Planning Application No: 3/2024/0416

Proposal: Proposed demolition of existing front porch and construction of single-storey extension to front, side and rear. First floor extension over existing pitched roof above garage.

Location: 23 Harewood Avenue Simonstone BB12 7JB

Block plan - 1:200

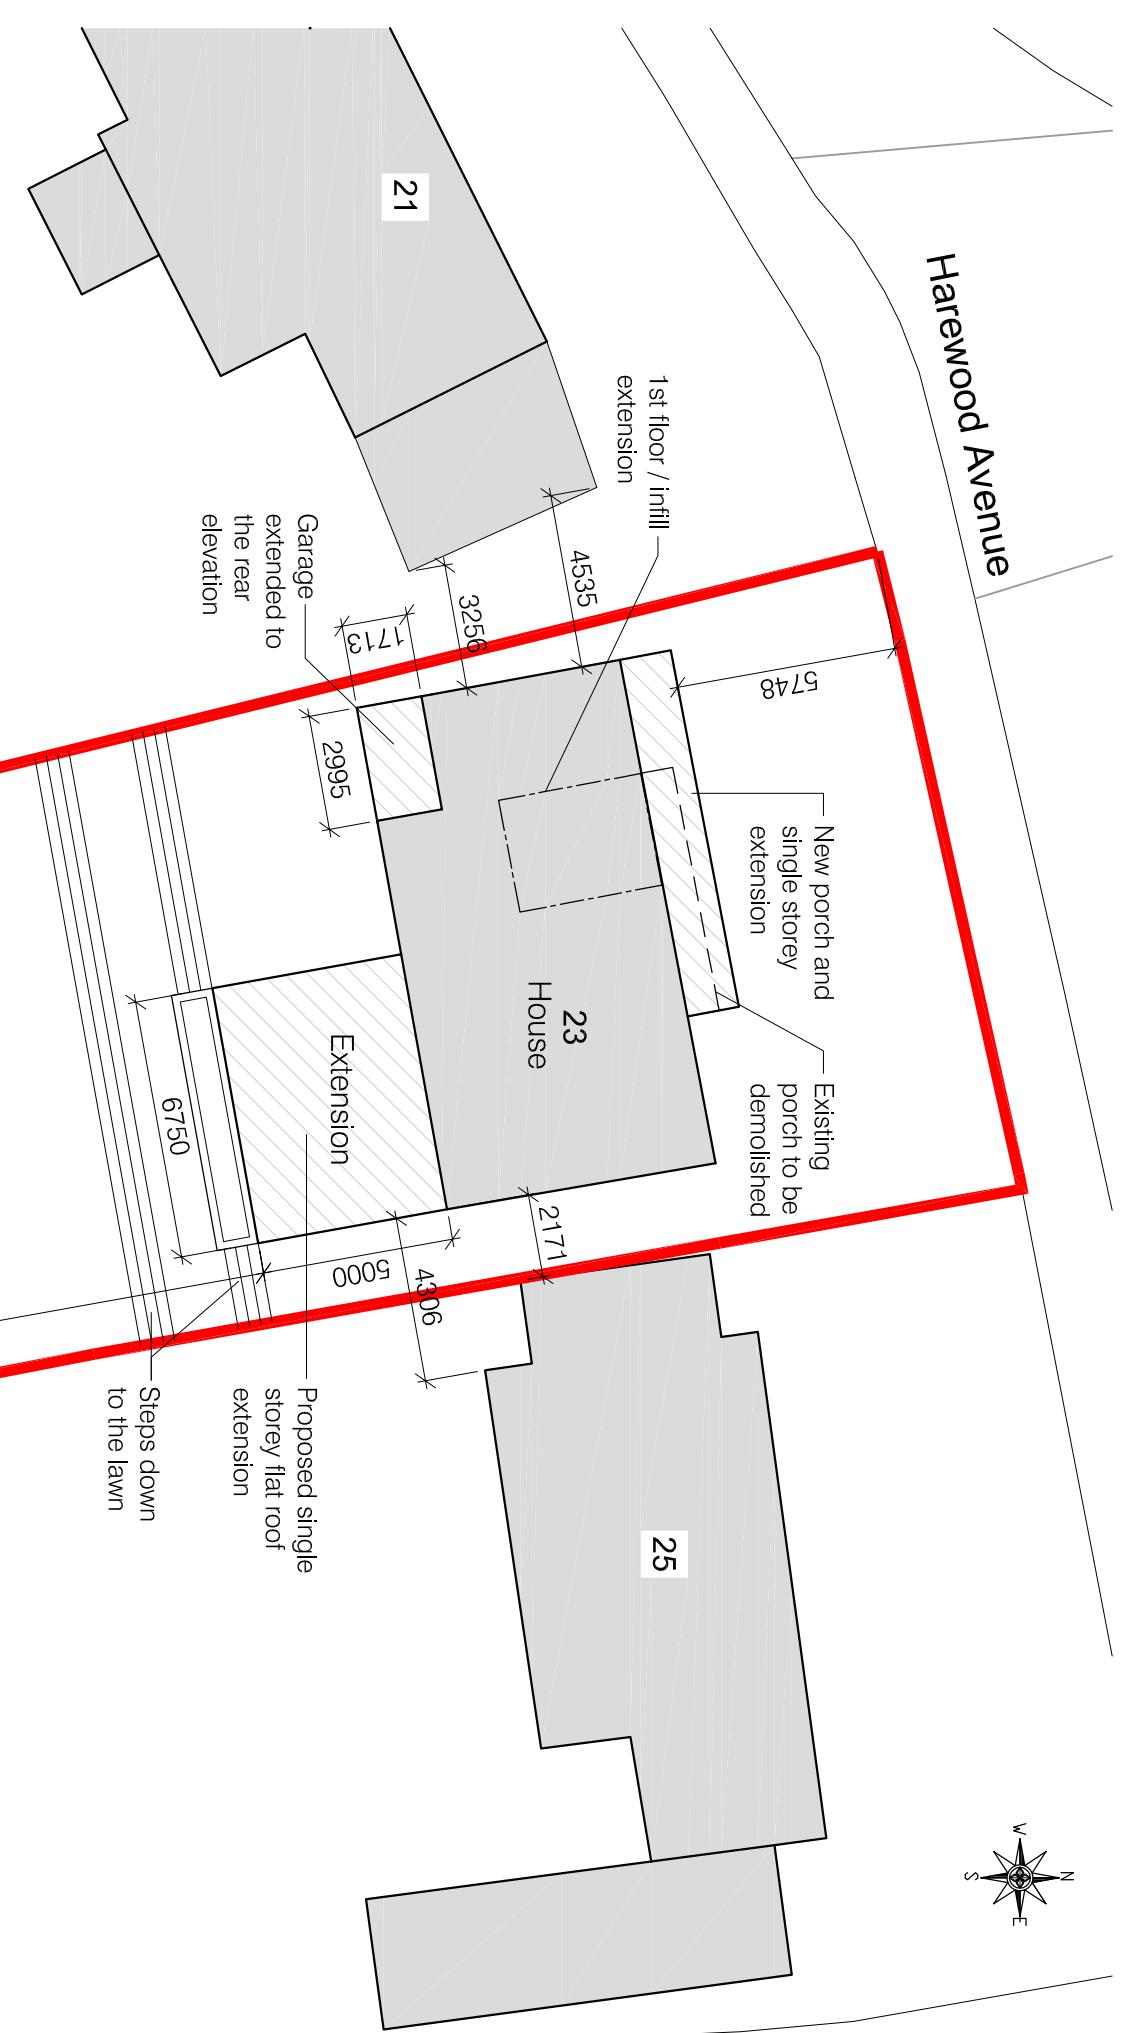
The parking areas must be constructed of a bound porous material and created before first occupation up until the lifetime of the dwelling existing in its proposed state. Reason: To ensure that satisfactory parking is provided before the dwelling hereby permitted becomes operative.
